From
THIRU PAVAN RAINA, I.A.S.,
Member-Secretary,
Madras Metropolitan
Development Authority,
No.8, Gandhi-Irwin Road,
Madras-600 008.

Letter No. Lr.No.A1/11035/91

Dated: 5.12.'91.

Sub: MMDA - Planning Permission -
Construction of residential
building (additional construction
of second floor) in Plot No.158/A
and Door No.27 at T.S.No.4/2A1 part
in Tamilnadu Housing Board, West C.I.T.
Nagar Scheme - Approved - Reg.
Ref: Direct submission in SBC No.588/91,
dated 21.5.'91.

GROUND FLOOR PLAN (EXISTING)

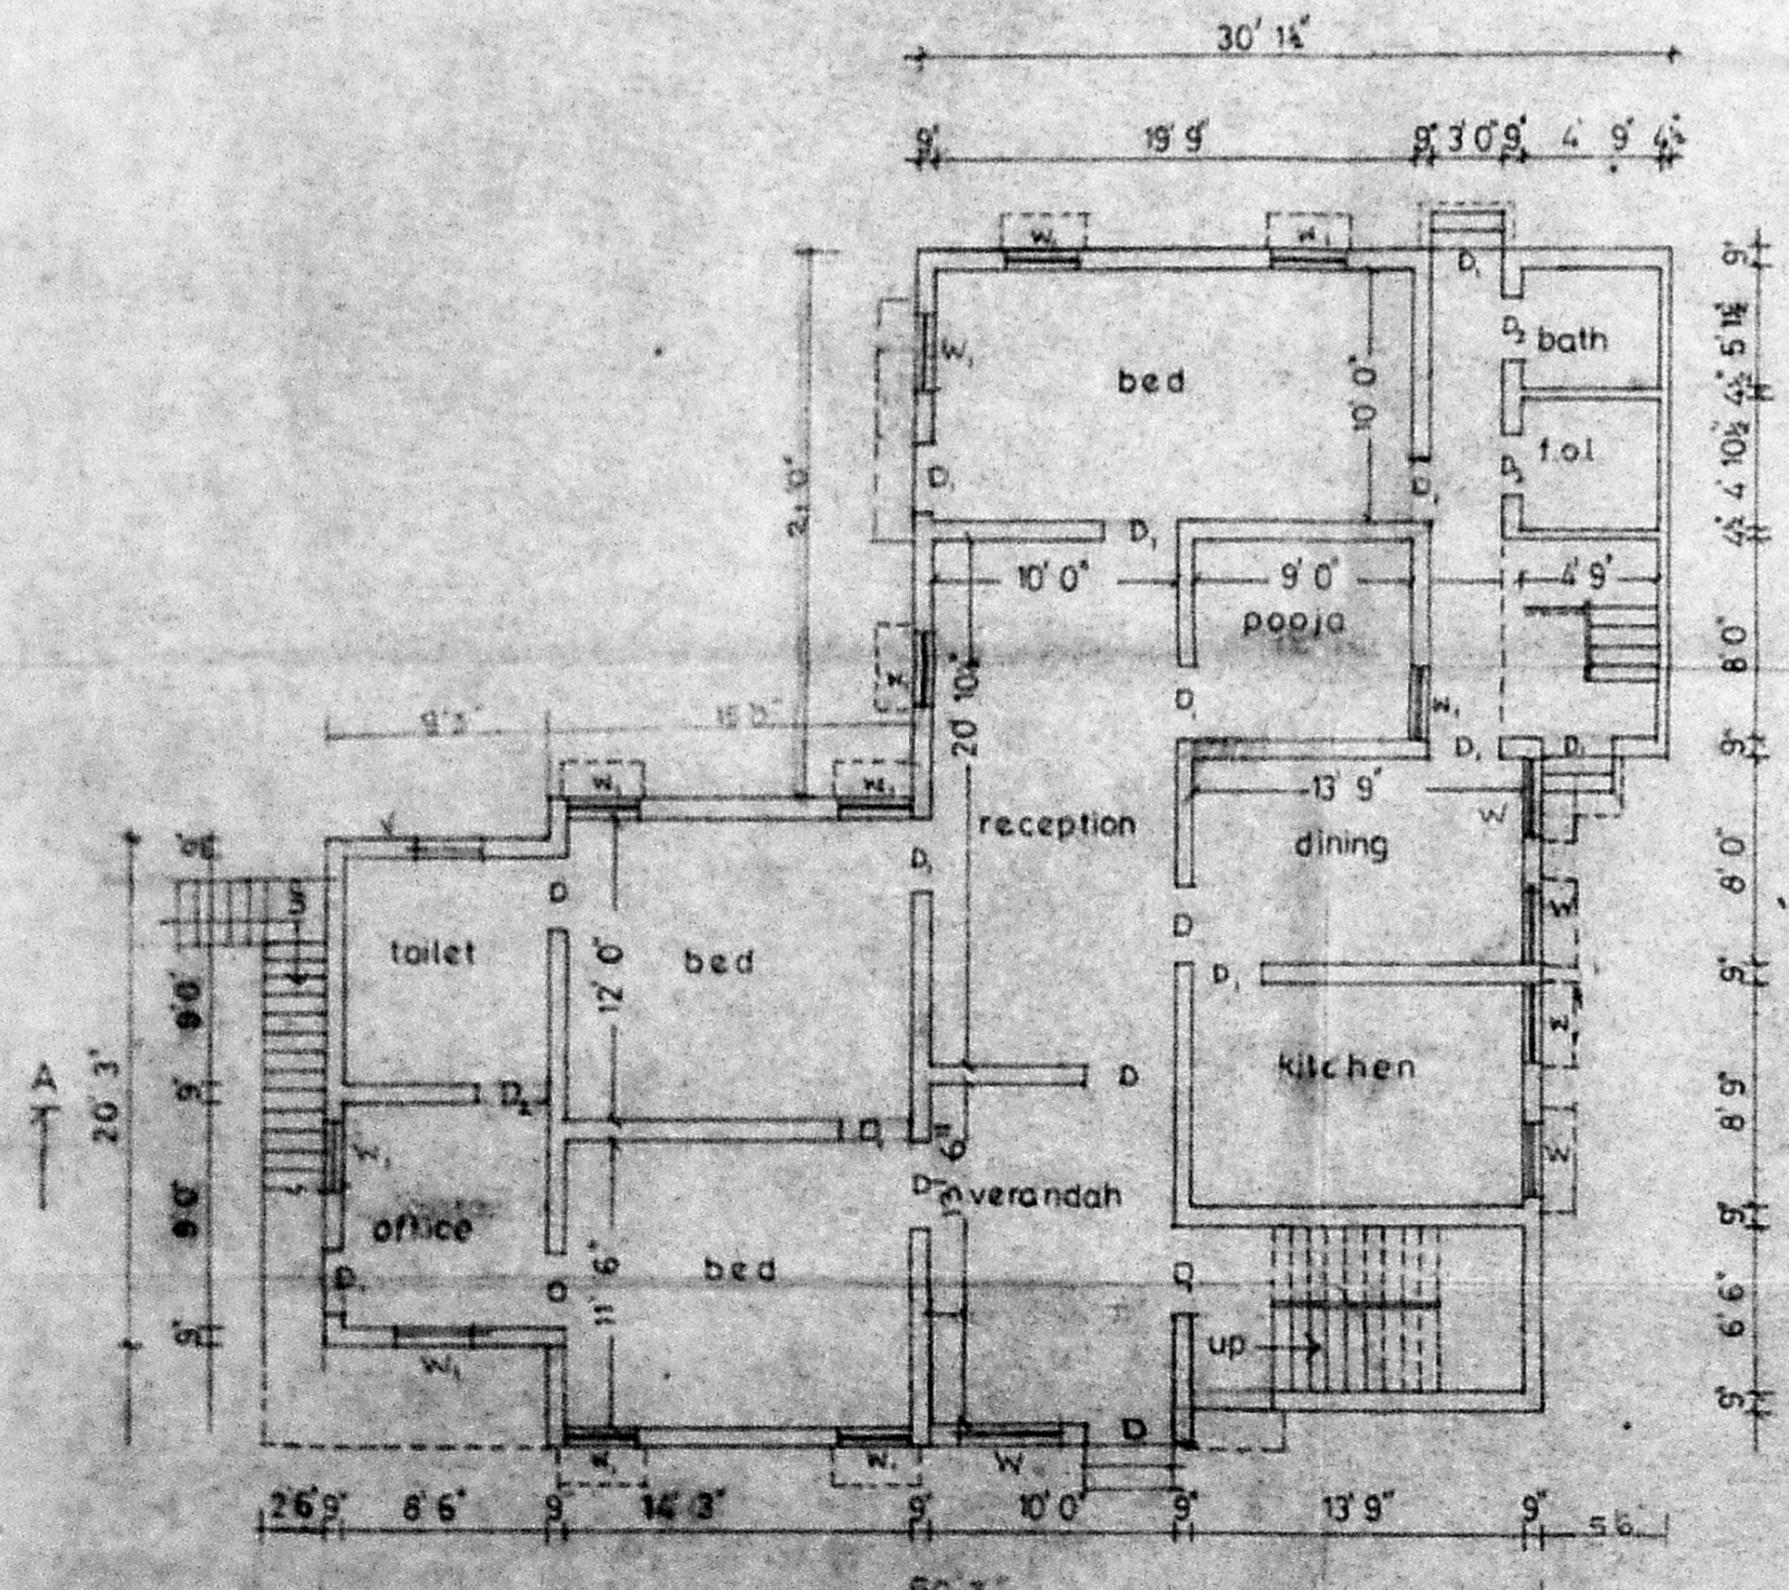
~~towards Regularisation charge by two separate Demand Drafts of~~
a Nationalised Bank in Madras City drawn in favour of the
Member-Secretary, MMDA, Madras-8 or in cash/and pay at MMDA
office Cash Counter between 10.00 A.M. and 4.00 P.M. within
10 days and after remit the said amount, you are requested to
remit the duplicate receipt to Area Plans Unit. You are also
requested to submit the Affidavit for ULC in Rs.5/- Stamp
paper duly attested by Notary Public. Planning Permission
Application will be returned unapproved if the amount are not
paid within the stipulated time. You are requested to furnish
5 sets of revised plan clearly showing the entire second floor
showing walls, parapets etc., without any ink corrections, tallying
breakup measurements with overall measurements on northern side and

(**) showing the Pooja, Office and
Kitchen rooms correctly in
Ground floor.
